Subject: RE: Planning Consultation on: WA/50/20/RES

Engineers Comments Regarding Surface Water Drainage

Application No: WA/50/20/RES
Registered: 21st September 2020
Site Address: Former Lanes End House West Walberton Lane Walberton BN18 0QS
Grid Reference: 495737 106877
Description of Works: Approval of reserved matters following outline consent WA/26/18/OUT for appearance, landscaping, layout & scale for the demolition of 1 No. dwelling & the erection of 6 No. dwellings (resubmission following WA/7/19/RES).

Southern Water MapGuide Browser

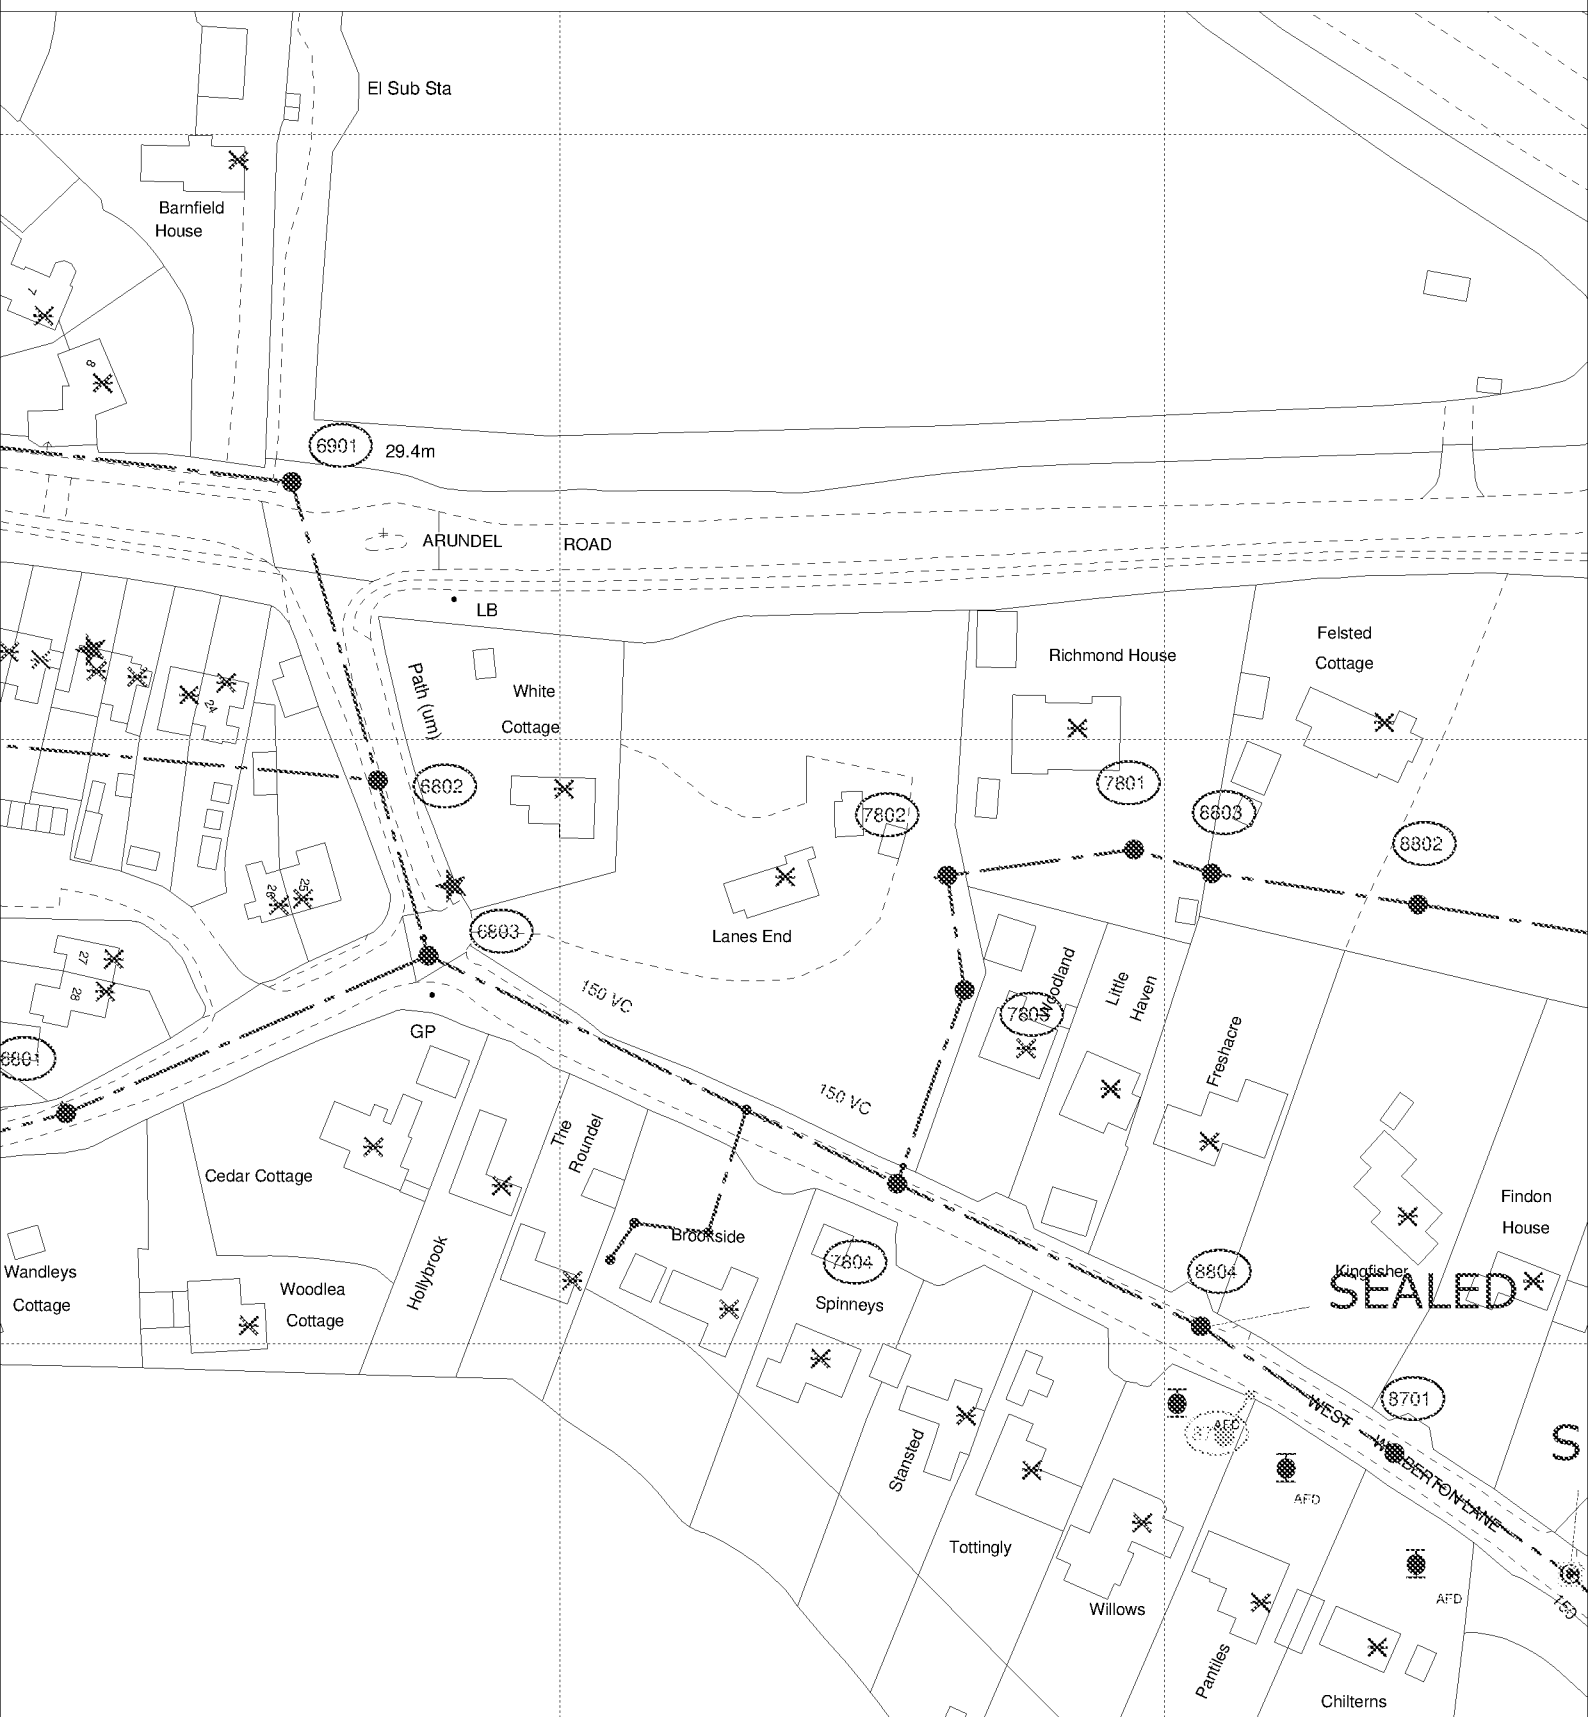
When the required easements are applied (5m from buildings, including garages, and 2.5m from property boundaries), and all root protection areas are excluded, most units cannot be drained using soakaways. In addition our mapping shows that there is a foul water sewer running along the eastern boundary of the site, within plot 6,

this would also require easements in agreement with Southern Water. Whilst permeable paving remains an option, diffuser units would have to be located 5m from the properties and plots 3-6 would be drained to the north.
